PLANNING CONSULTATION RESPONSE

| Application No | 2026/0028 |
| Proposal | Demolition of existing club and associated garage and the construction of 5 new dormer bungalows |
| Consultee | BMBC PROW – C Farley |

Drawing Title
BLOCK PLAN

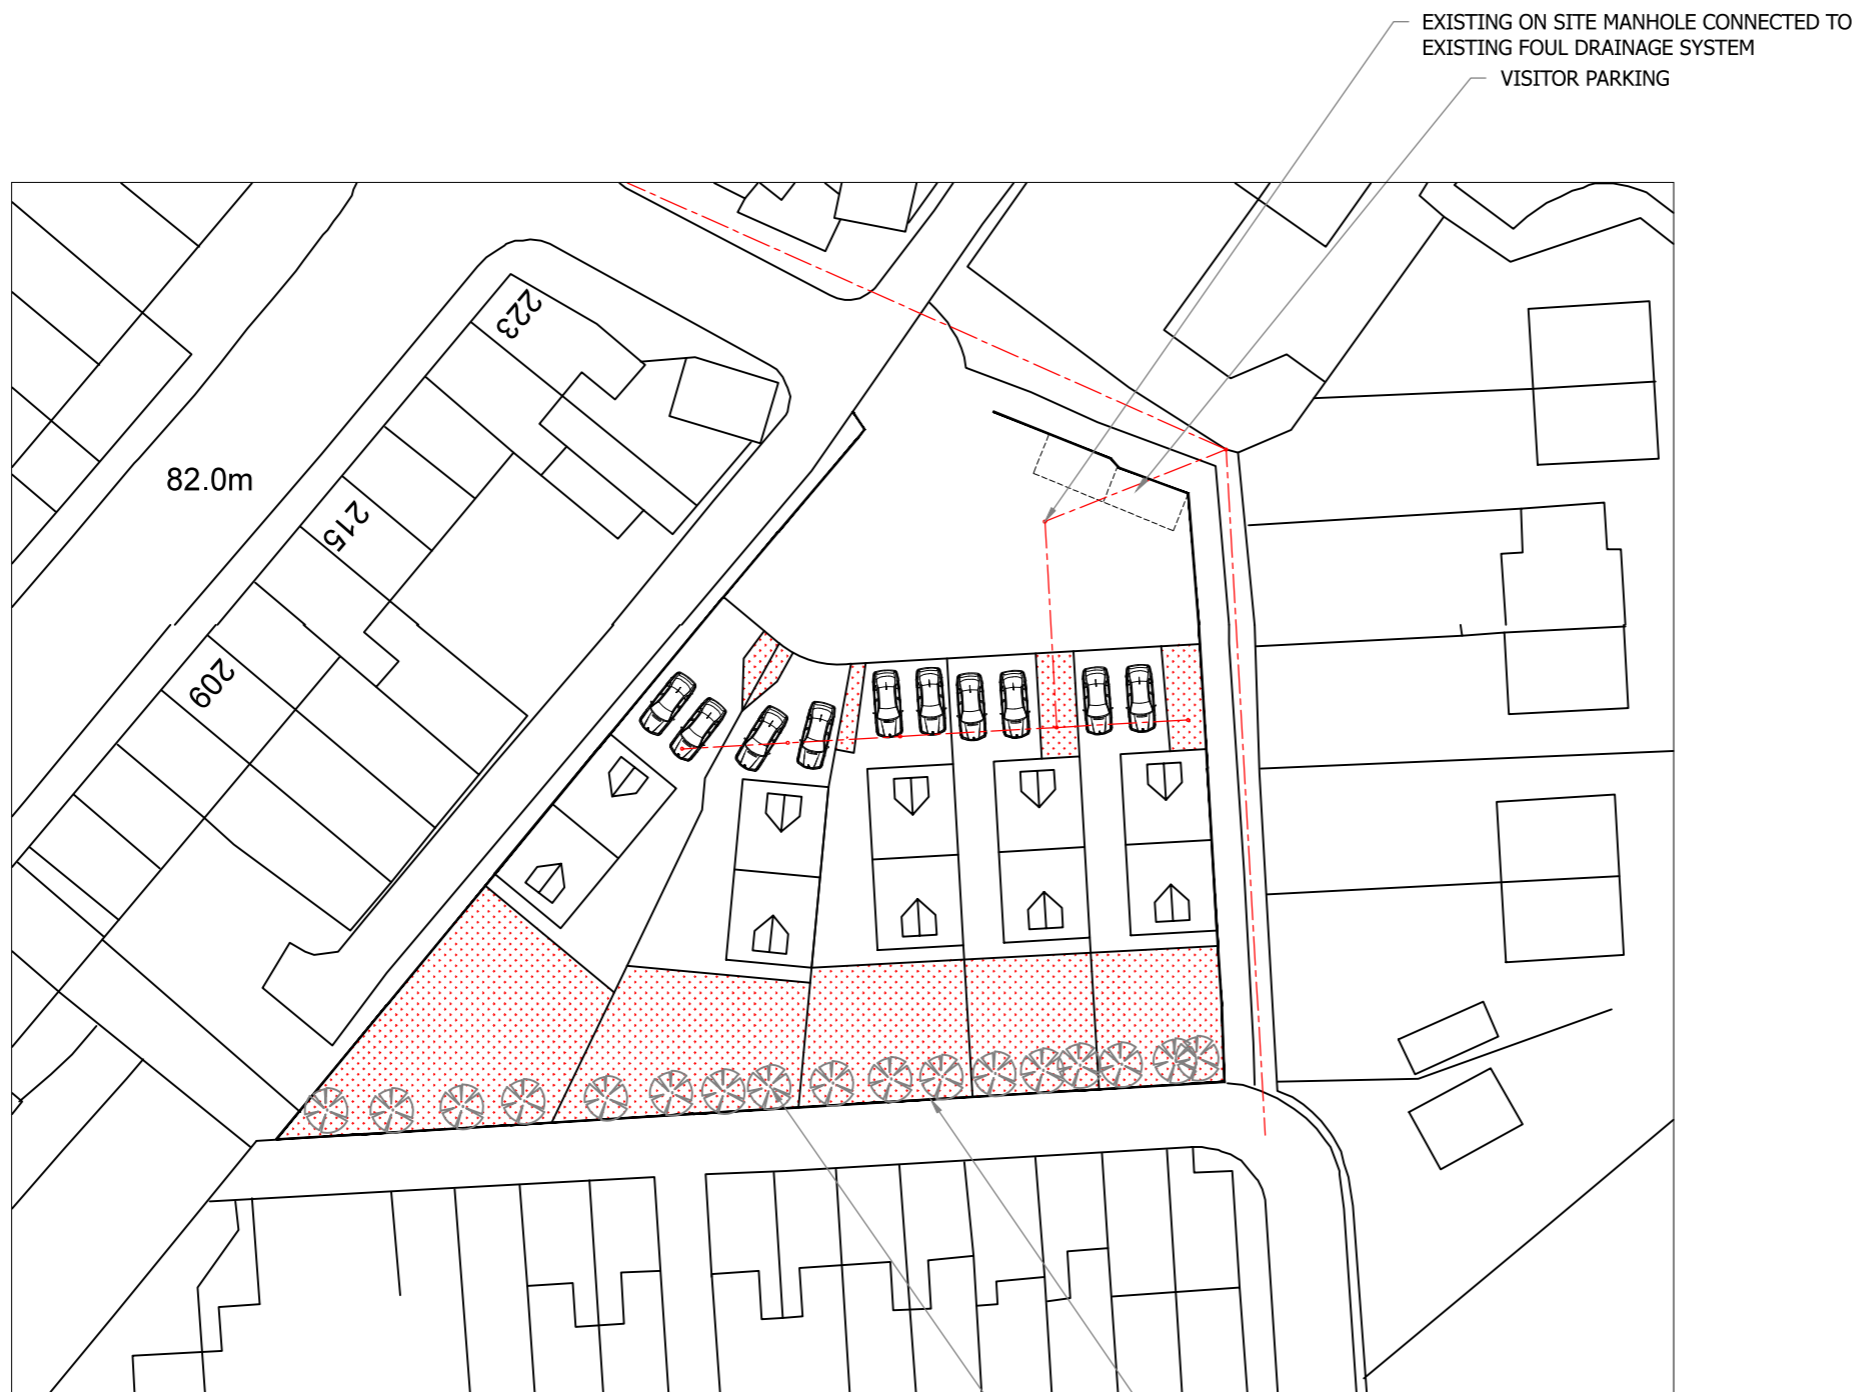
A public right of way (Cudworth FP 18) runs alongside the proposed development site. Safe public access on the right of way should remain available at all times, with **no obstruction of or encroachment onto the width of the path and no building debris, storage of materials or parked vehicles limiting access at any time.**

The property on the east of the development should be as far away from the boundary treatment as possible and should not drain onto the adjacent public footpath.
